EAST PRESTON PARISH COUNCIL

Re: Planning Application EP/158/19/HH – The Breakers, 29 Tamarisk Way, East Preston, BN16 2TE

REV	DATE	DESCRIPTION
A	09.10.19	Revised to South Elevation. Dormer added and cladding altered to North Elevation.
B	04.11.19	Planning Issue
C	25.11.19	North Elevation cladding added Issued for Planning

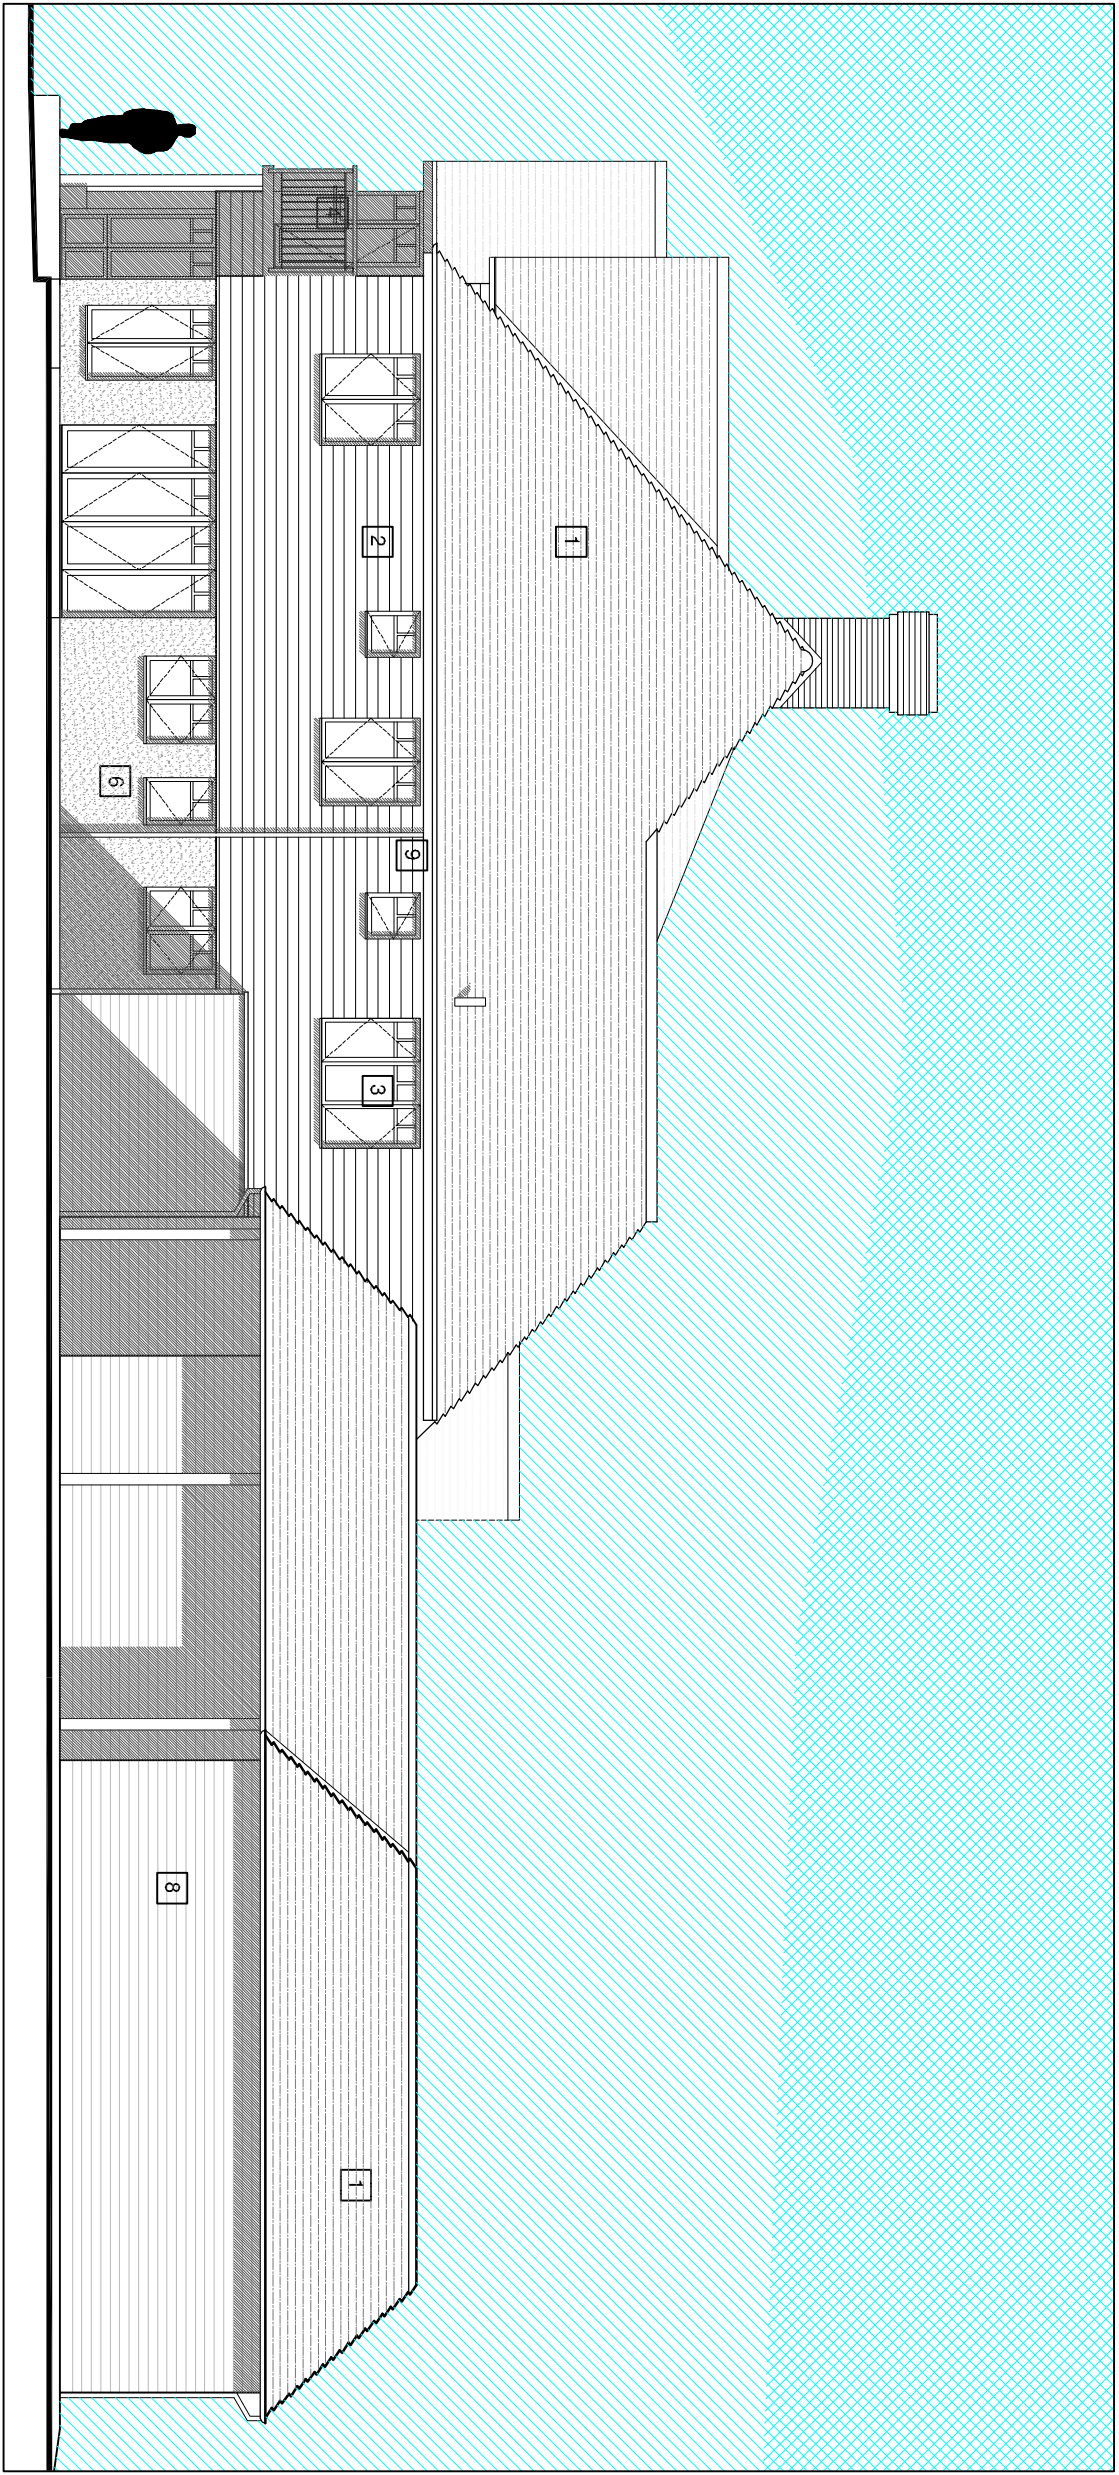
One of the headlines of Policy 2: Design in Character Area One is "Development proposals [...] will [...] protect the view from the beach." The overwhelming changes being proposed for the southern elevation clearly do not meet that headline.

It may be an anomaly with the drawings but the proposed roof over the eyebrow window on the northern elevation appears NOT to set the apex of the roof above the apex of the eyebrow. This would likely result in a very out-of-kilter feel to that window/roof combination. The National Planning Policy Framework allows Local Planning Authorities to refuse Planning Permission on the grounds of poor design.

The Breakers, 29 Tamarisk Way, East Preston Boundary Wall and Gates as Proposed

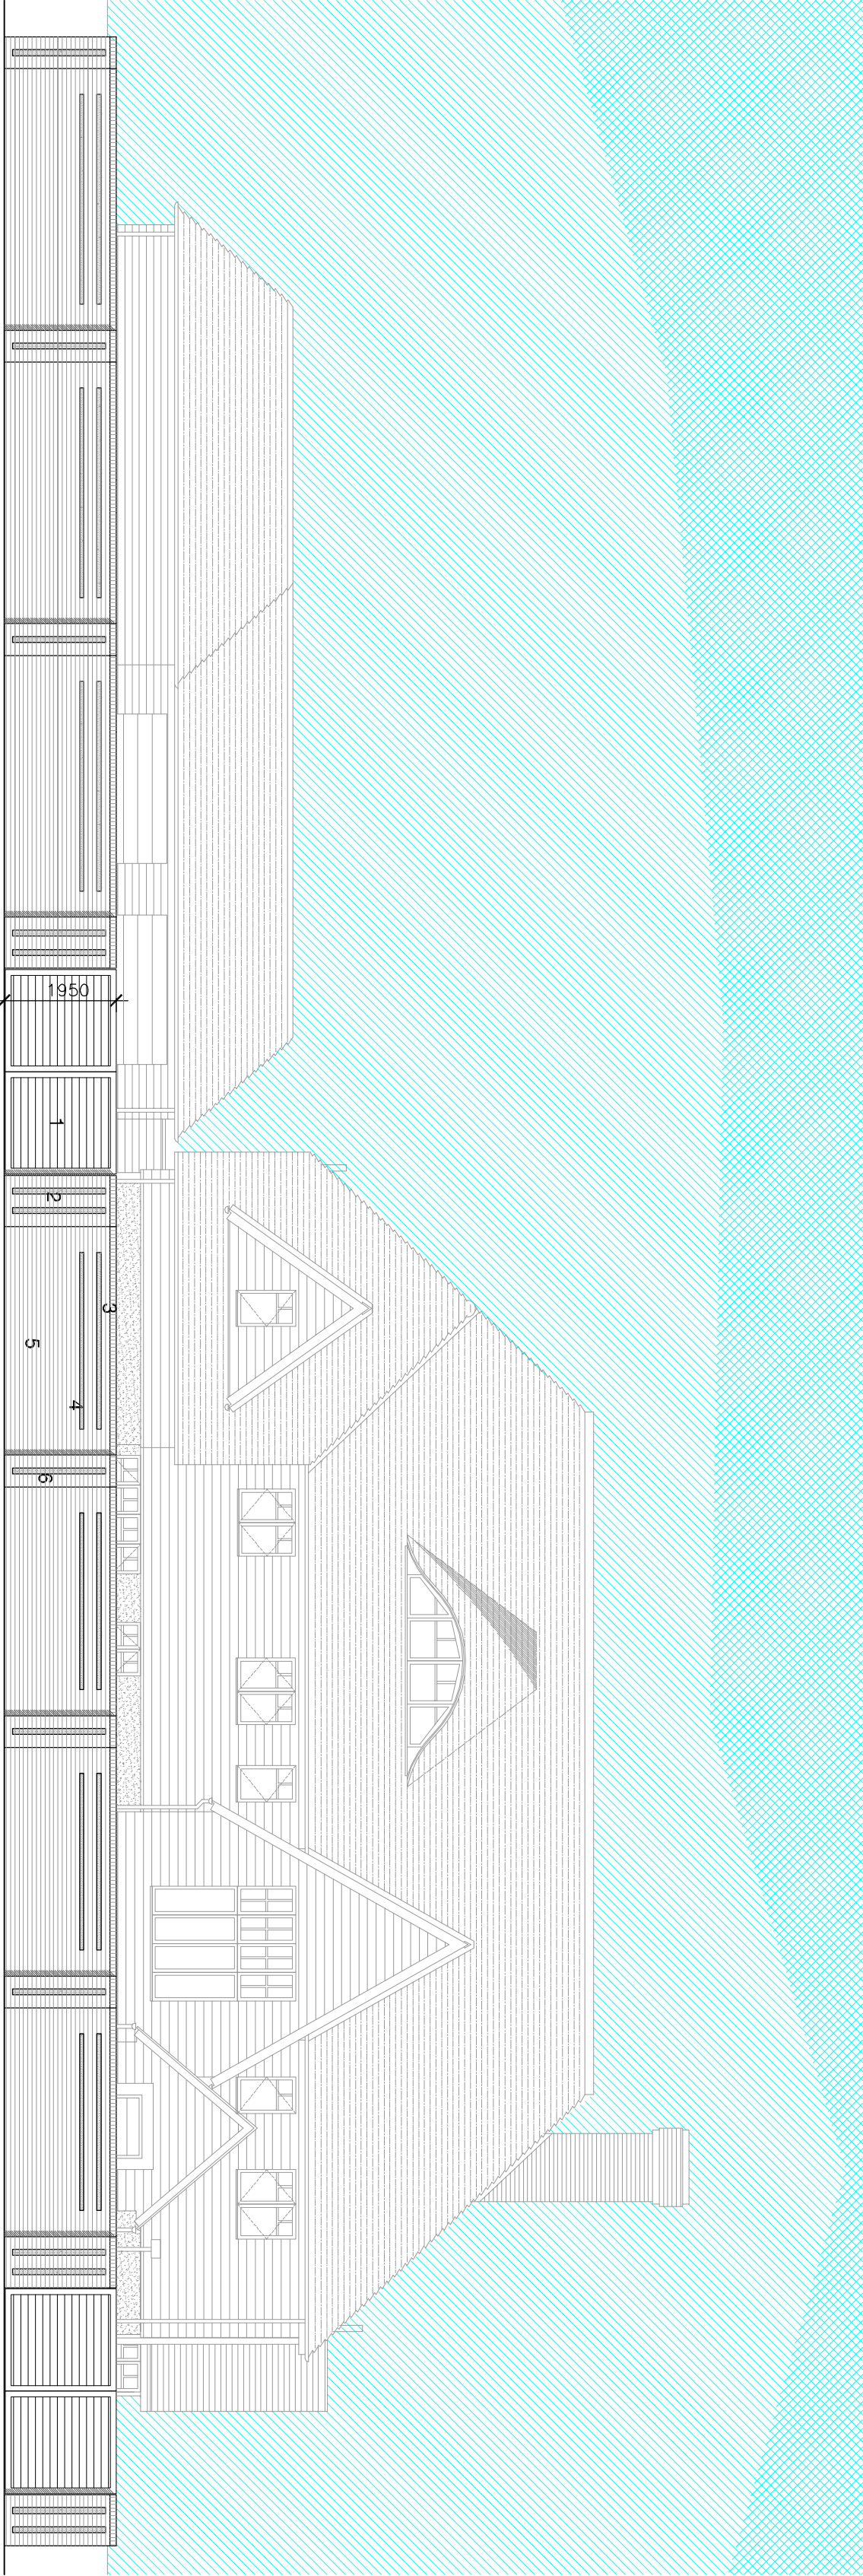
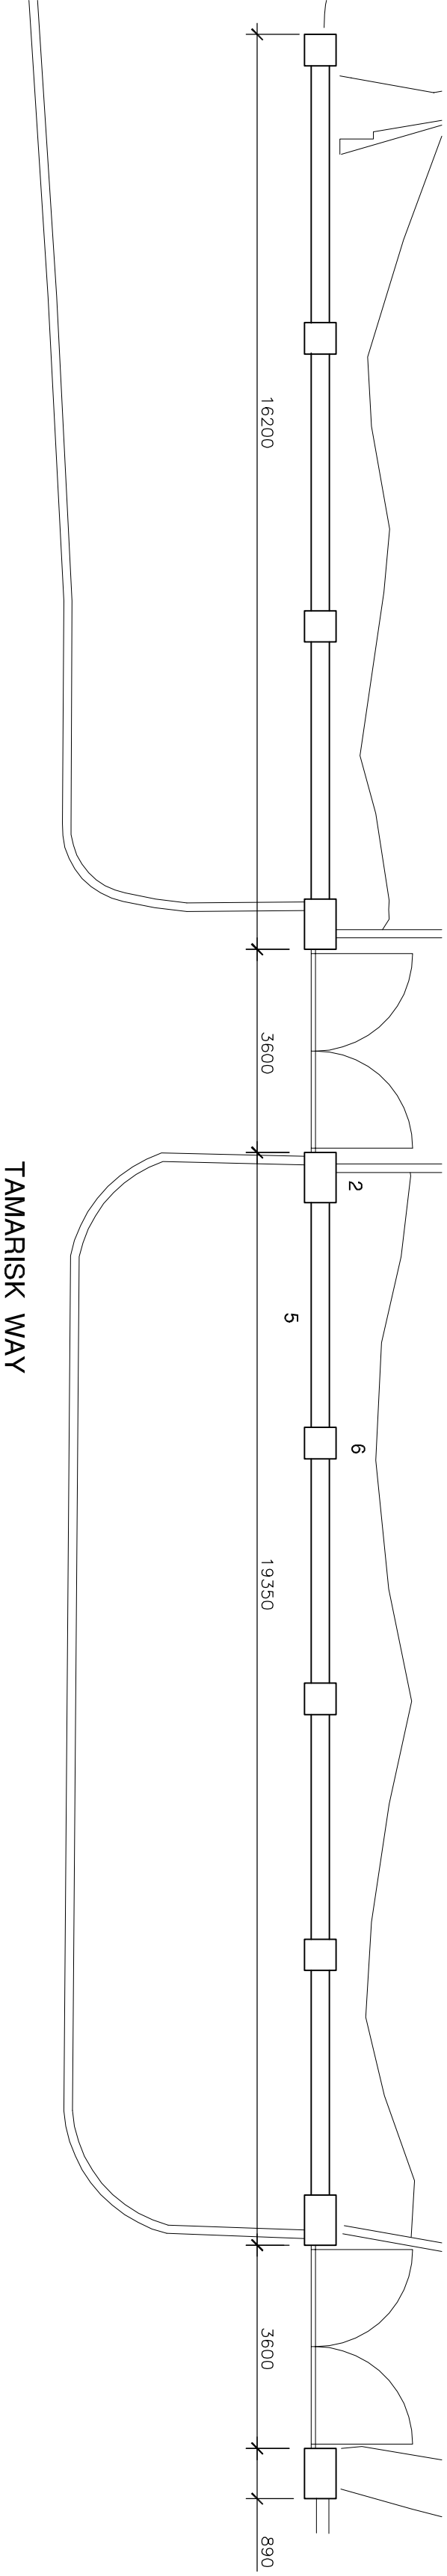
The existing northern boundary wall is very characterful and pretty in its design, unique in the locality. The proposed new boundary wall will be out of keeping with the existing property, neighbouring properties and the general feel of the Willowhayne private estate. It is contrary to section 4.26 of the East Preston Neighbourhood Plan which states, "the construction of high front walls or fences should be resisted."
